# City of Portland, Maine - Building or Use Permit Application

Permit No: 03-1101	Issue Date: SEP 10 2003	CBL: 275 1012001
-----------------------	----------------------------	---------------------

Proposed Project Description: Build a 26x35 one story detached garage	Signature:	Signature:
PEDESTRIAN ACTIVITIES DISTRICT (P.A.D.)		
Action: <input type="checkbox"/> Approved <input type="checkbox"/> Approved w/Conditions <input type="checkbox"/> Denied		
Signature:	Date:

ADDRESS: 81 WARWICK STREET INSPECTION DATE: MAY 12, 2003
PORTLAND, MAINE SCALE: 1"=30'

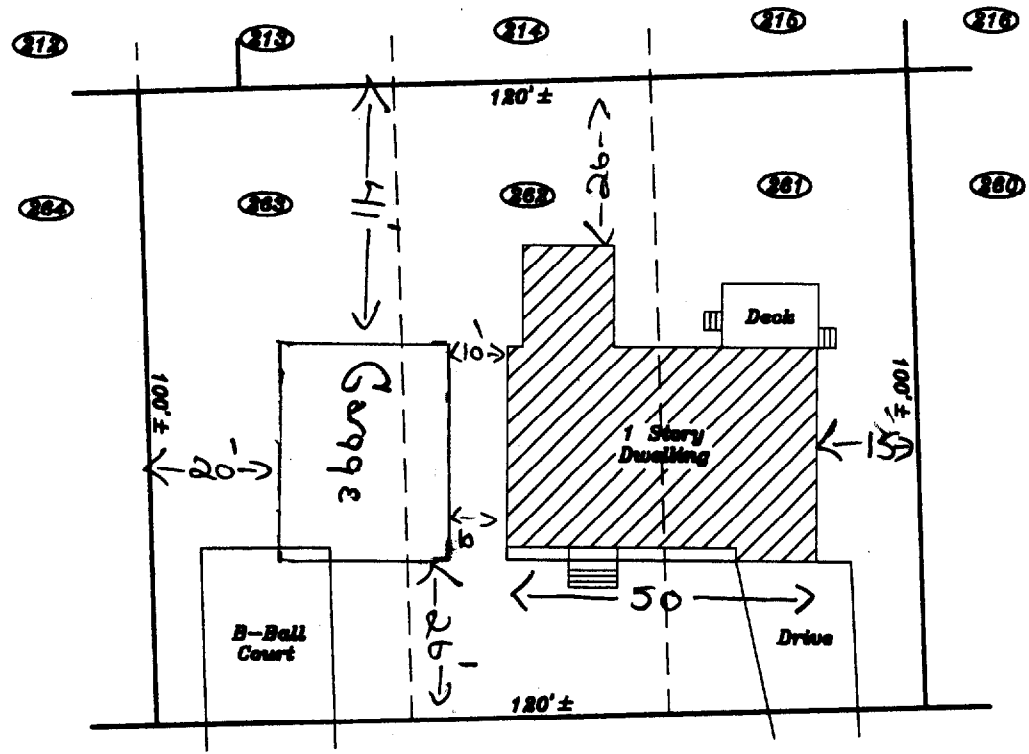
- 1) The contractor/property owner is required to establish the property lines for setback identification. This permit is being approved based on the front setback being 26' as indicated on the plot plan
- 2) This permit is being approved on the basis of plans submitted. Any deviations shall require a separate approval before starting that work.

FOUNDATION PLAN  
 1/4" = 1'-0"

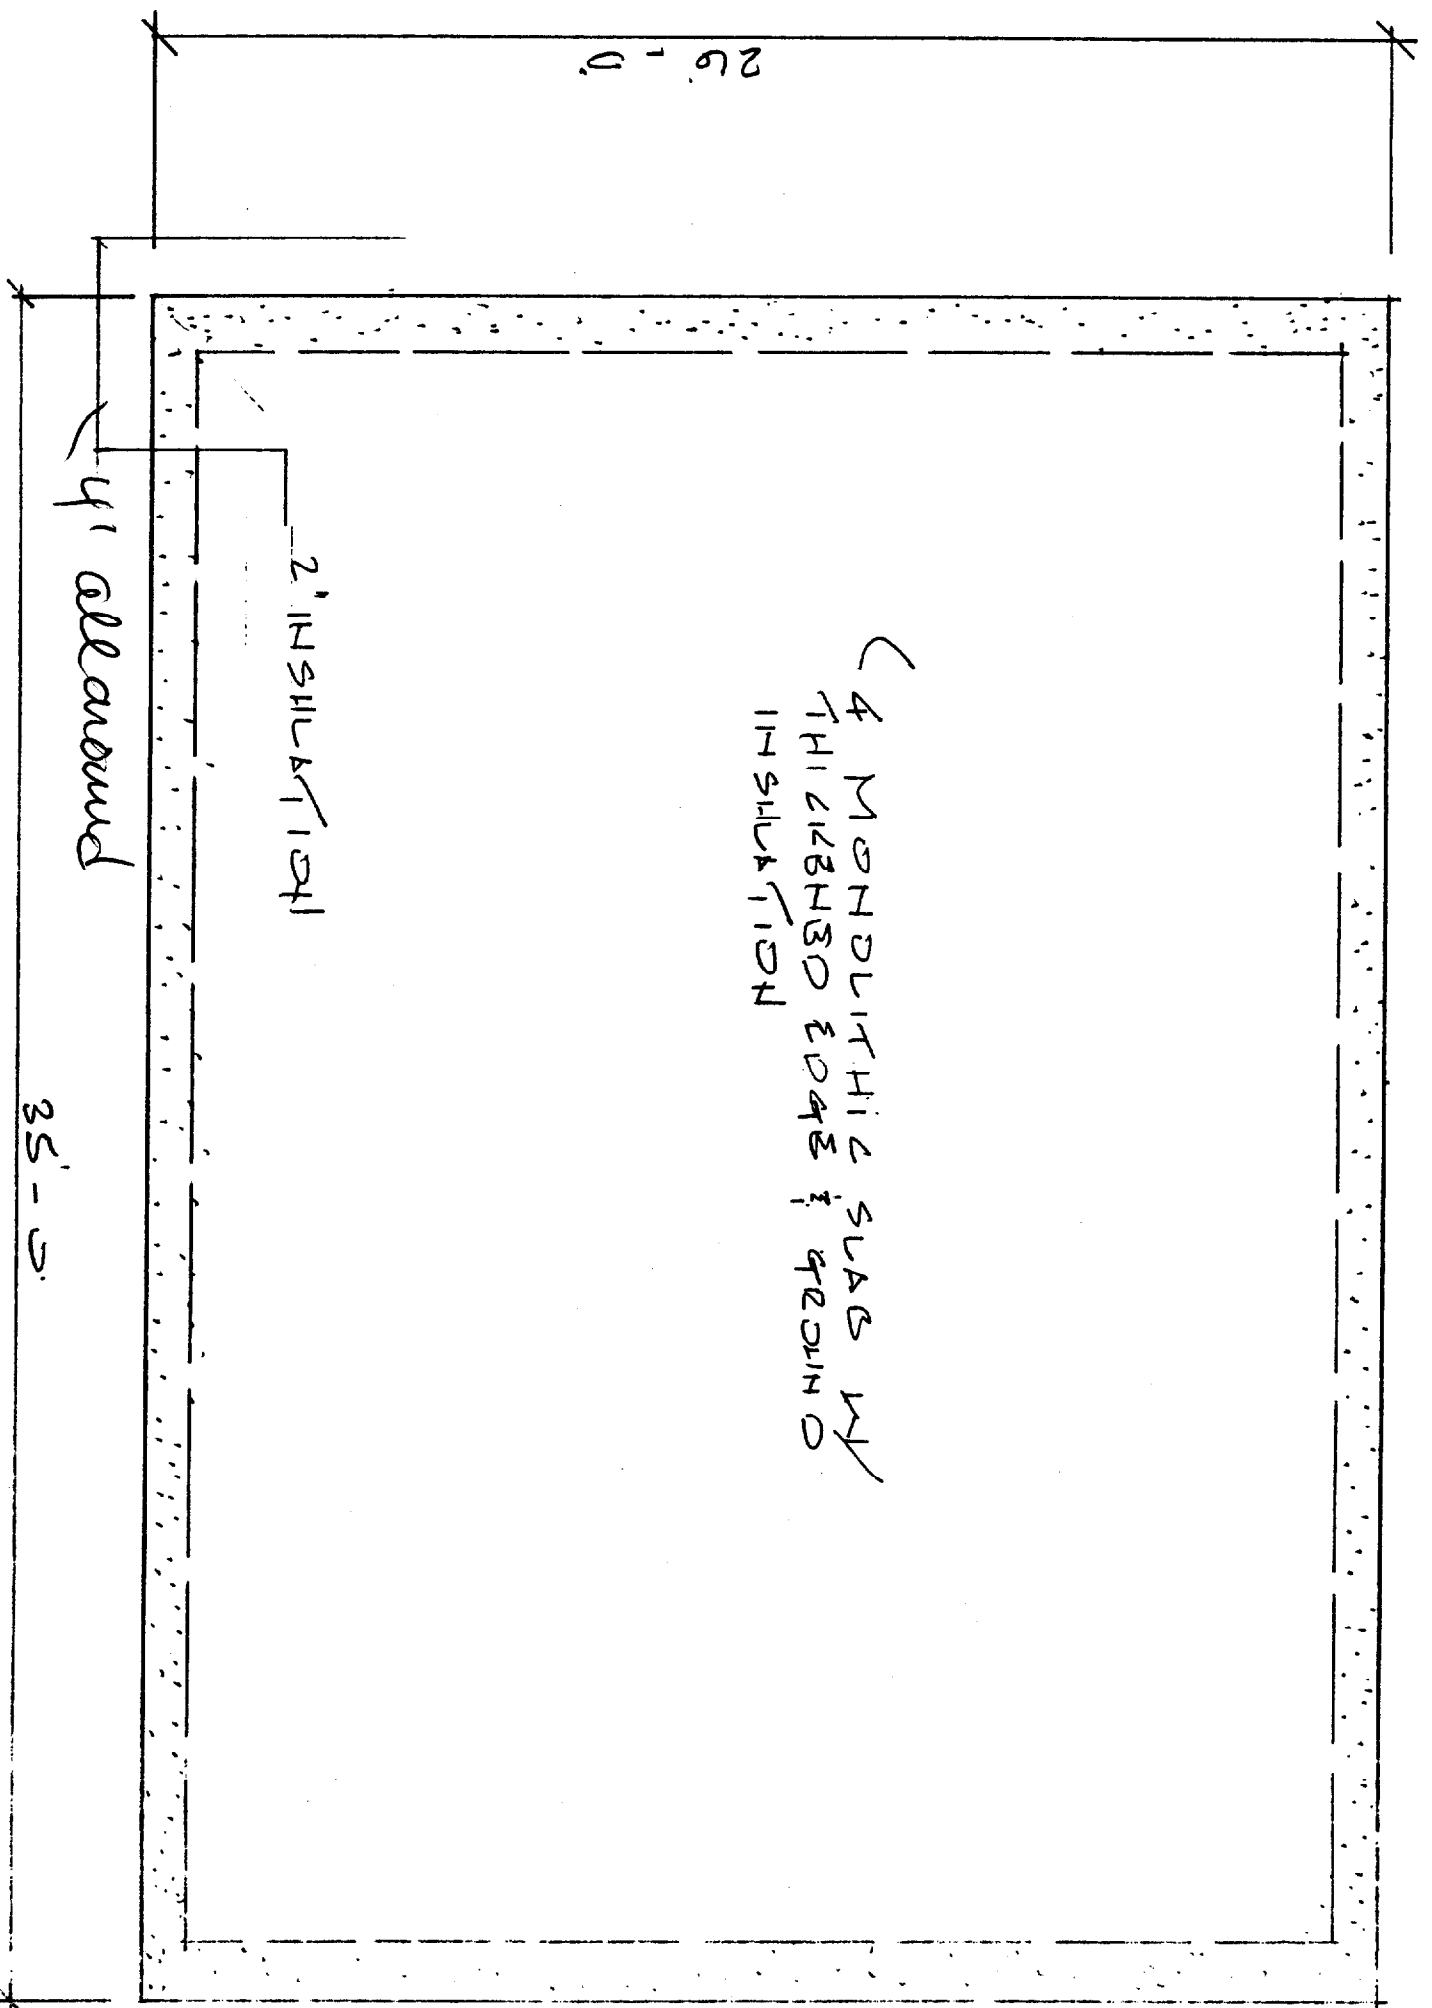
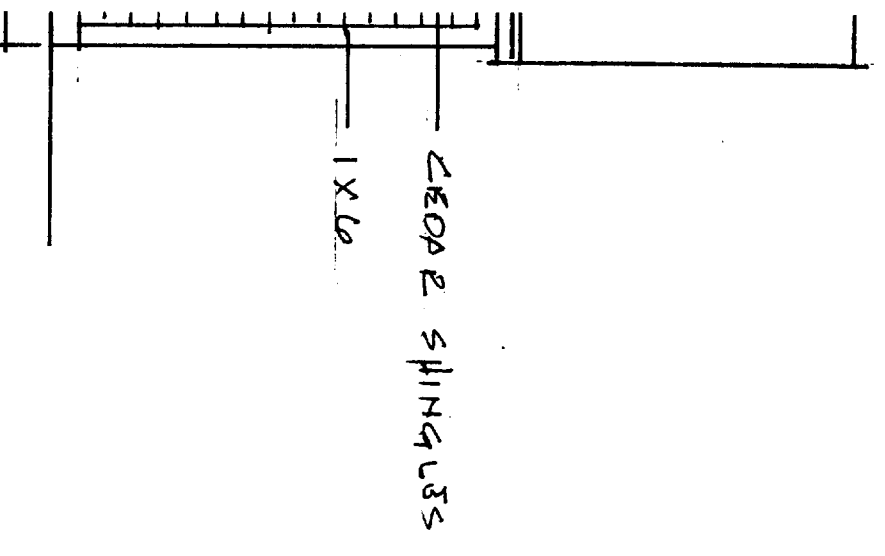
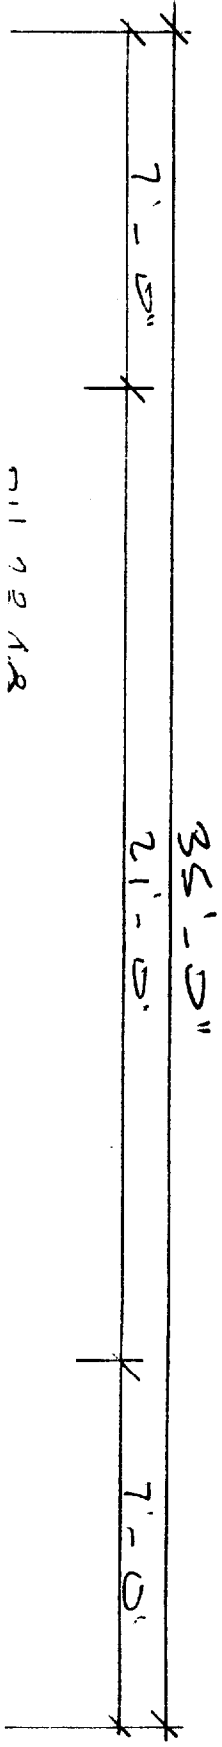
9/18/03 Met w/Guy L. to review FPSF criteria. This plot had 16-24" of top soil and they have brought sand fill in. The base below loam was gravel. They will either trench the edges and run 2" rigid under ~~the~~

concrete and extend 4' or per the NAHB specs provide enough sand to offset the need for insulation.

That calculation would be 24" of sand. JB See criteria
